# HAY CREEK VALLEY

SITUATED IN THE SOUTHEAST QUARTER OF SECTION 33 AND THE SOUTHWEST QUARTER OF SECTION 34, TOWNSHIP 11 SOUTH, RANGE 67 WEST OF THE SIXTH PRINCIPAL MERIDIAN, COUNTY OF EL PASO, STATE OF COLORADO.

DATE OF PREPARATION: 9/18/2023  
 SCALE: 1"=200'  
 SHEET 2 OF 2

HAY CREEK VALLEY

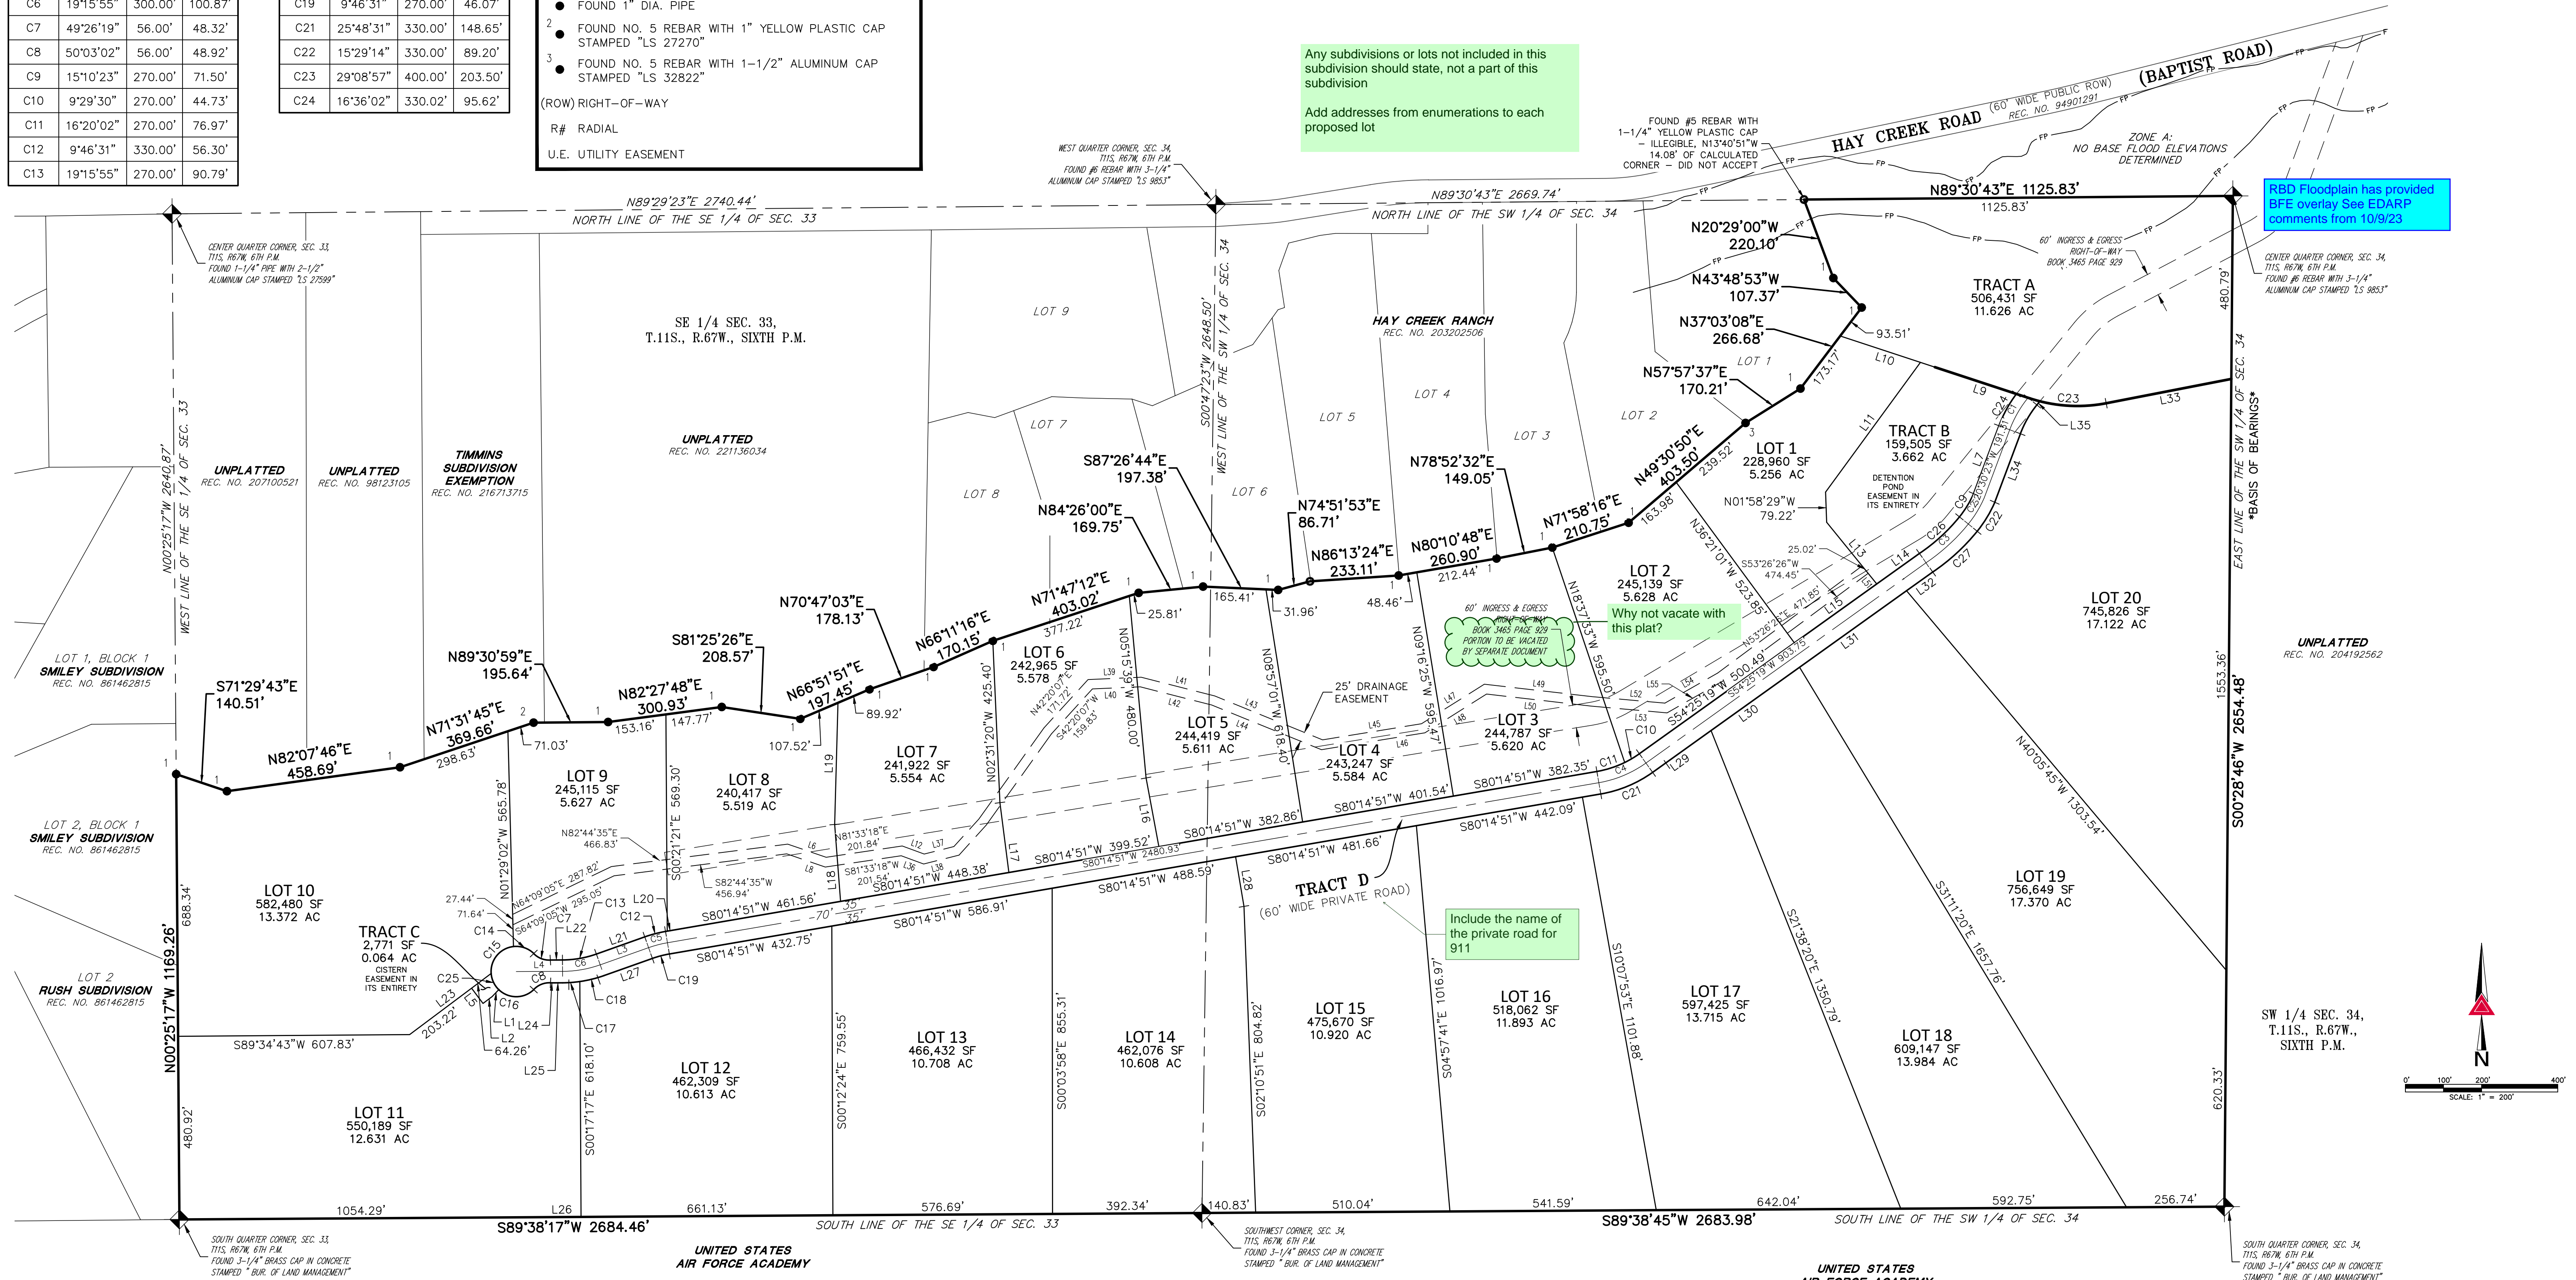
**LDC 8.4.2.B.3**  
 Unsuitable Building Areas. Areas within lots or tracts which reflect 1 or more of the following characteristics shall be deemed unsuitable for building and shall be identified as no build areas on the plat:

Please Identify those areas on each individual Lot

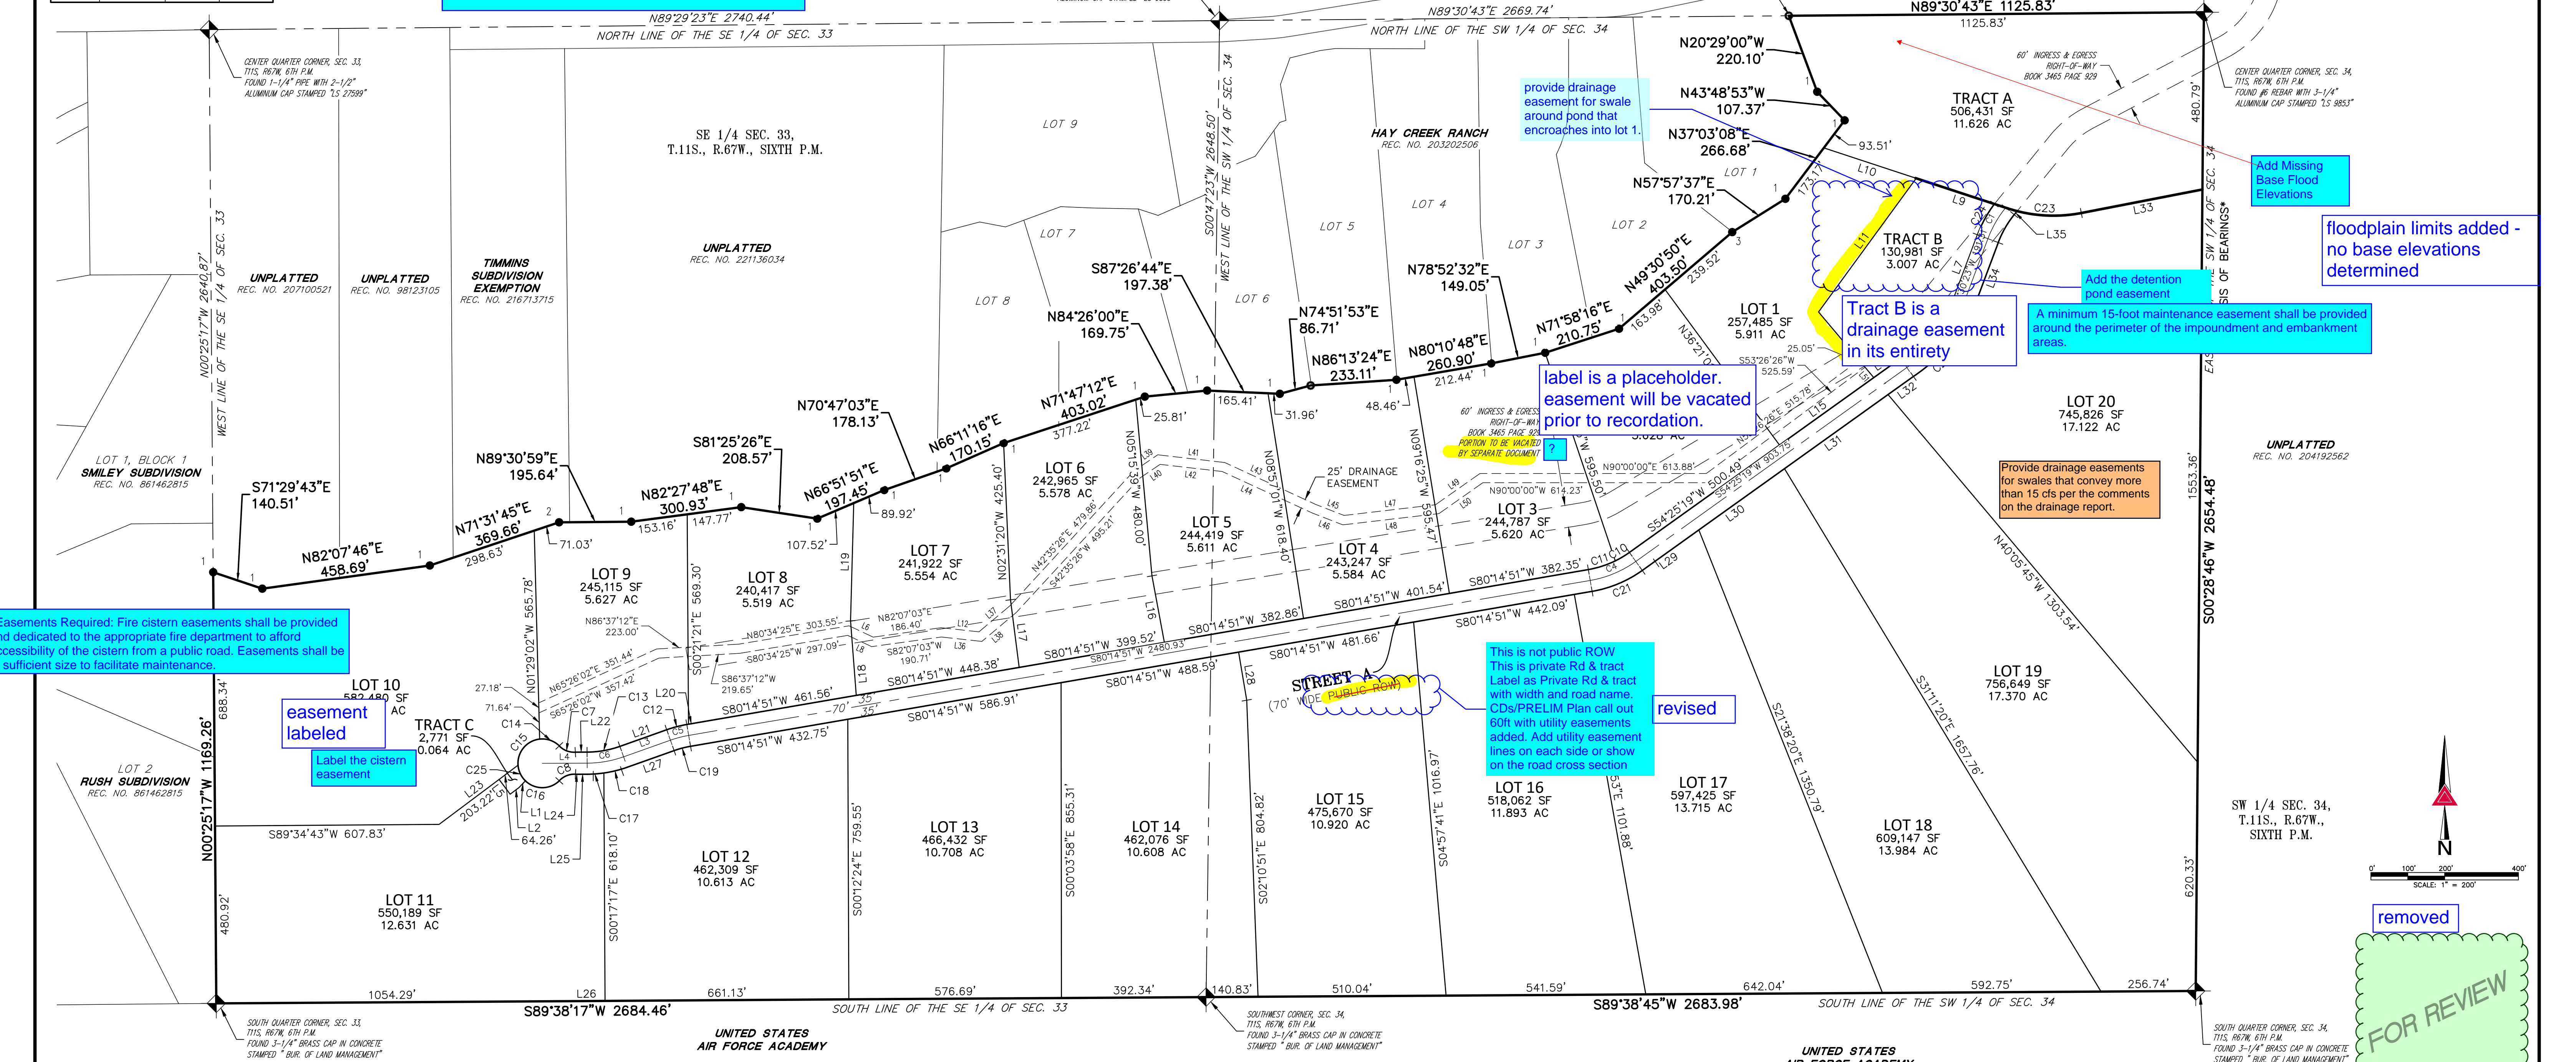
Easements Required: Fire cistern easements shall be provided and dedicated to the appropriate fire department to afford accessibility of the cistern from a public road. Easements shall be of sufficient size to facilitate maintenance.

Label the cistern easement

This is not public ROW  
 This is private Rd & tract Label as Private Rd & tract with width and road name. CDs/PRELIM Plan call out 60ft with utility easements added. Add utility easement lines on each side or show on the road cross section

Provide drainage easements for swales that convey more than 15 cfs per the comments on the drainage report.

Add the detention pond easement

A minimum 15-foot maintenance easement shall be provided around the perimeter of the impoundment and embankment areas.

Add Missing Base Flood Elevations

provide drainage easement for swale around pond that encroaches into lot 1.
